Thanet Extension Offshore Wind Farm
Development Consent Order: EN010084
Deadline 1: 15th January 2019

Written Representation

We welcome the opportunity to comment on the application submitted to the Planning Inspectorate (PINS) for the Thanet Extension Offshore Wind Farm proposal. Kent Wildlife Trust (KWT) strongly **object** to this development proposal based on the chosen landfall option and what we perceive to be a lack of consideration for valid alternatives to the onshore cable route that we believe would have less of an environmental impact.

Figure 4.5 Cross Section of above ground TJB

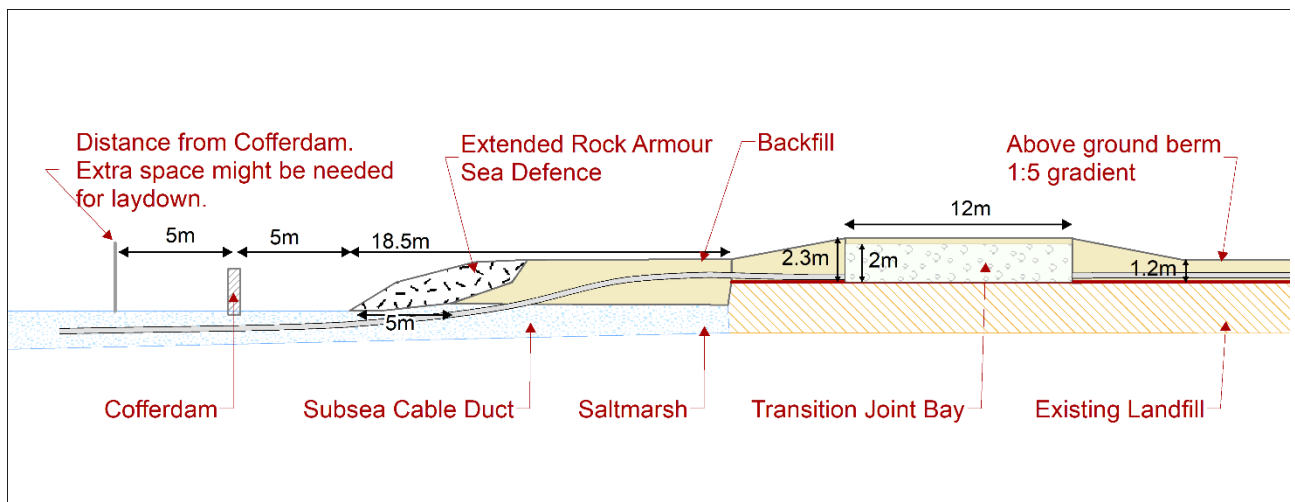
4.8.9	<p>We are highly concerned that the applicant is already stated that '<i>HDD may not be feasible</i>' for some options. We feel this is precipitating an argument to justify going above ground (cable installation method 2). It is premature to say that '<i>HDD may not be feasible</i>'. Permits not been issued to do site investigations and we have full confidence that the results of site investigation works will demonstrate that it is feasible to go below ground and eliminate uncertainties about the nature of the landfill.</p> <p>HDD is the best method to avoid environmental features such as saltmarsh⁵, therefore if the application is accepted, HDD should be the only cable installation method considered⁴</p>
